Please ask for: Ms Iqraa Malik
Email: iqraa.malik@terraquest.co.uk
Telephone: 0121 234 1390
Our Ref: FP/203/21/HH
Your Ref:
Date: 21st October 2021

Application for Planning Permission for Works or Extension to a Dwelling

Development: Erection of single storey side extension to create garage with balcony over following the demolition of existing carport
Location: 17 Blakes Road Felpham PO22 7EE

Plans & Elevations	SCALE	1:200	SHEET	A3
	DATE	September 2021		
	DRAWING NO			
Proposed New Garage at 17 Blakes Road, Felpham	2109/01			A

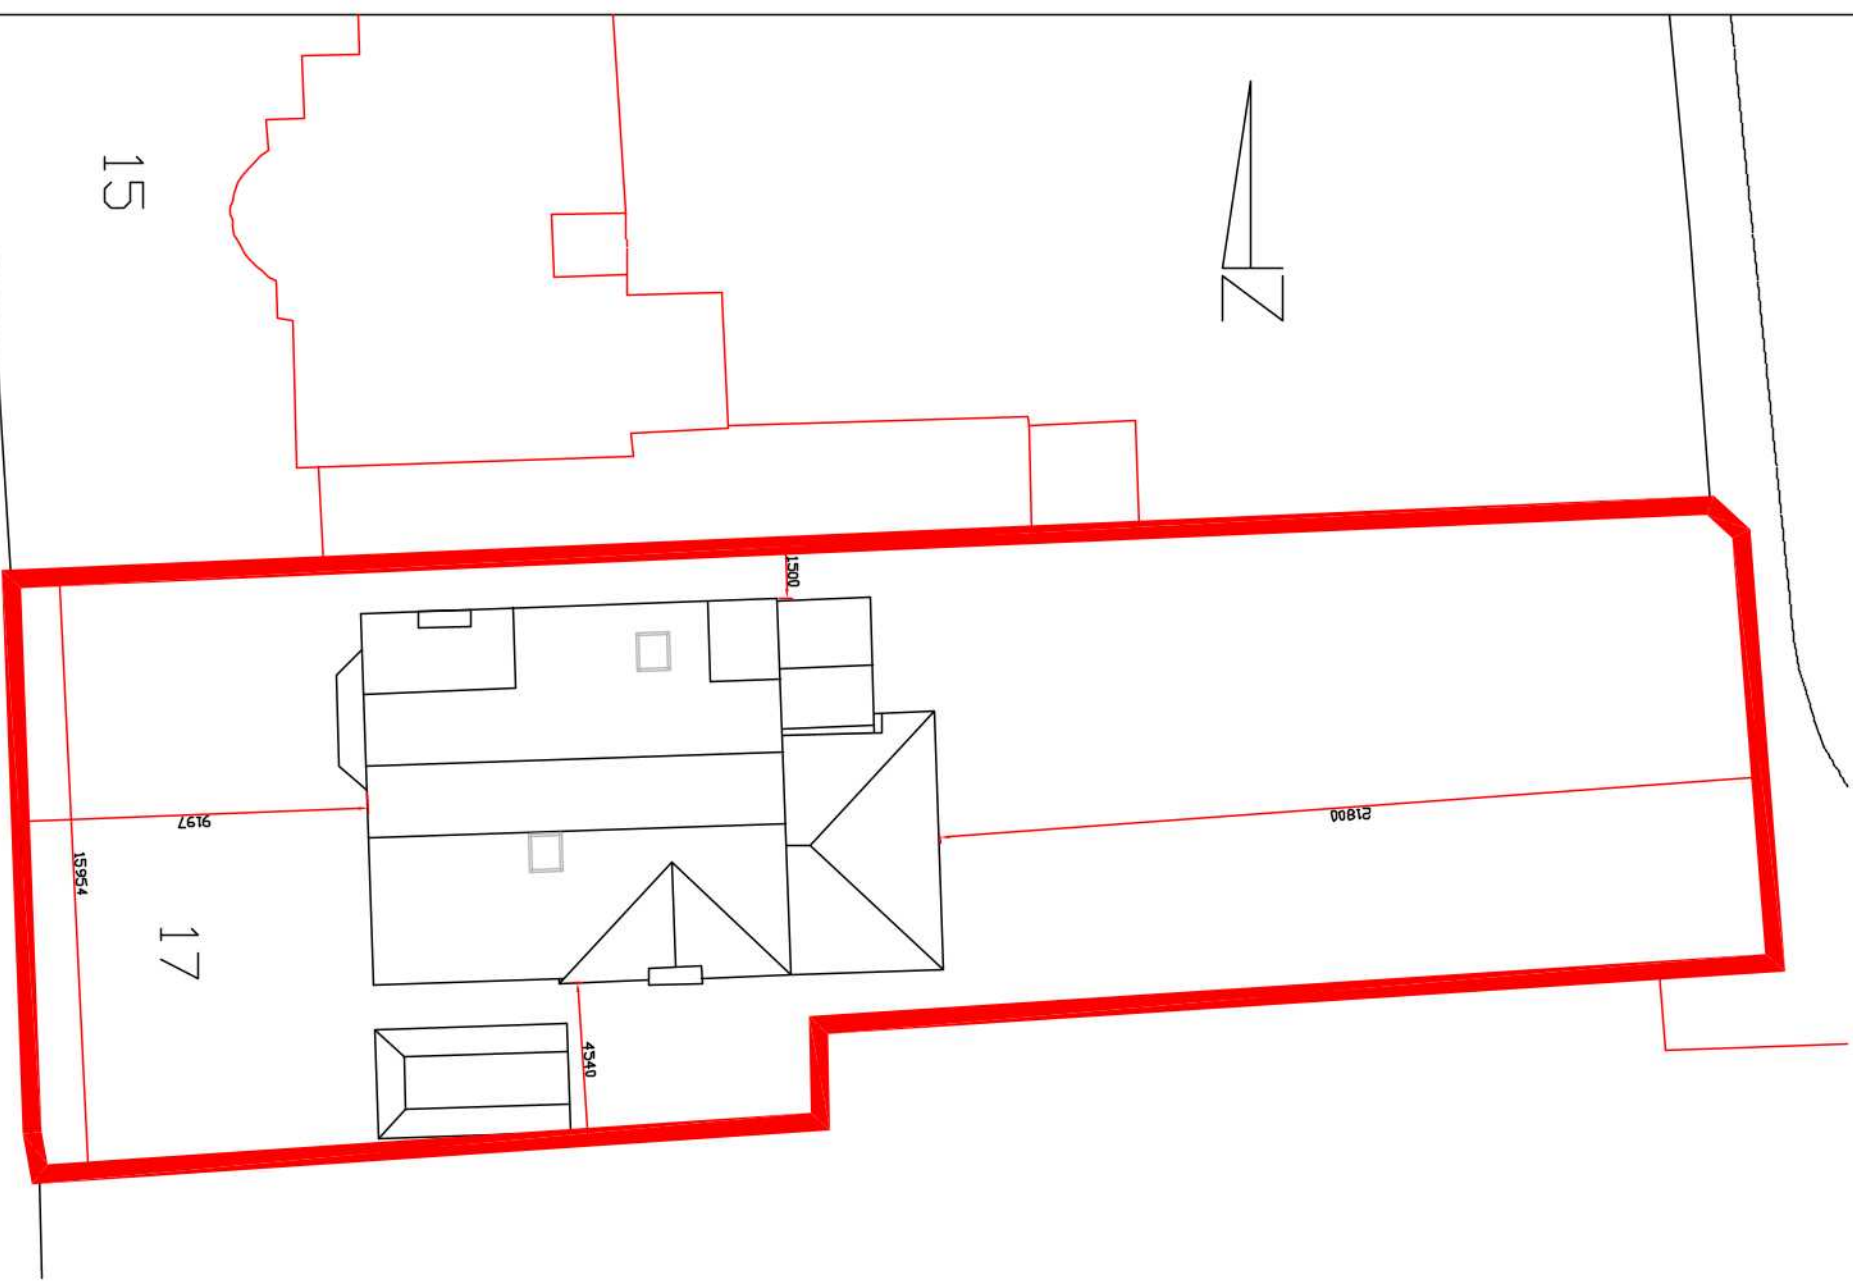
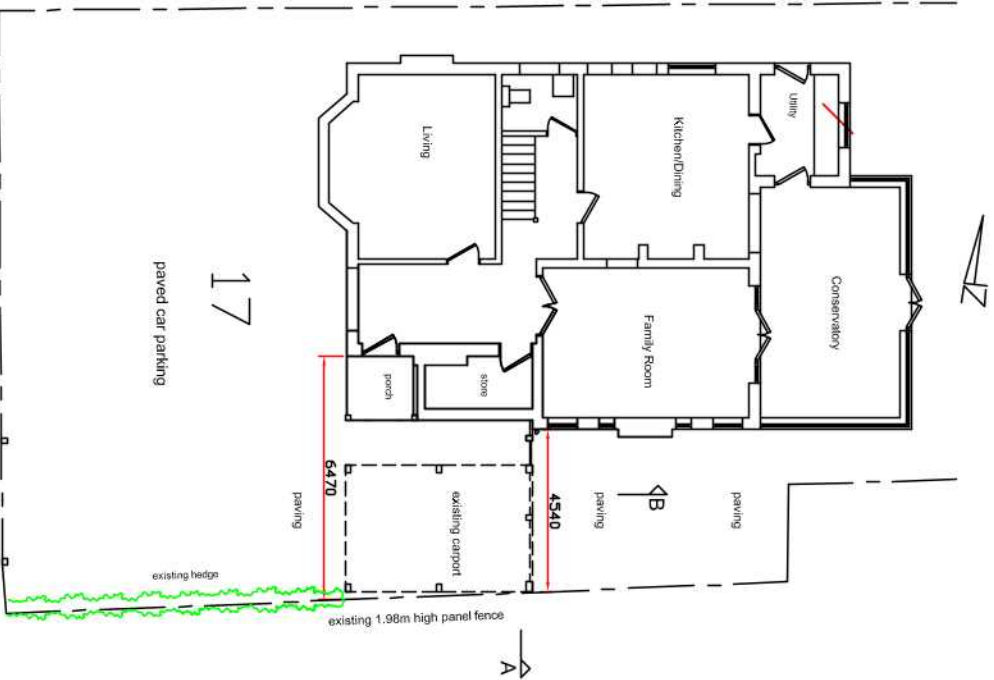
Please submit clearly labelled existing ground floor plan, existing roof plan and existing/proposed first floor plans at a scale of 1:50 or 1:100. Further details can be found in the Validation Requirements List.
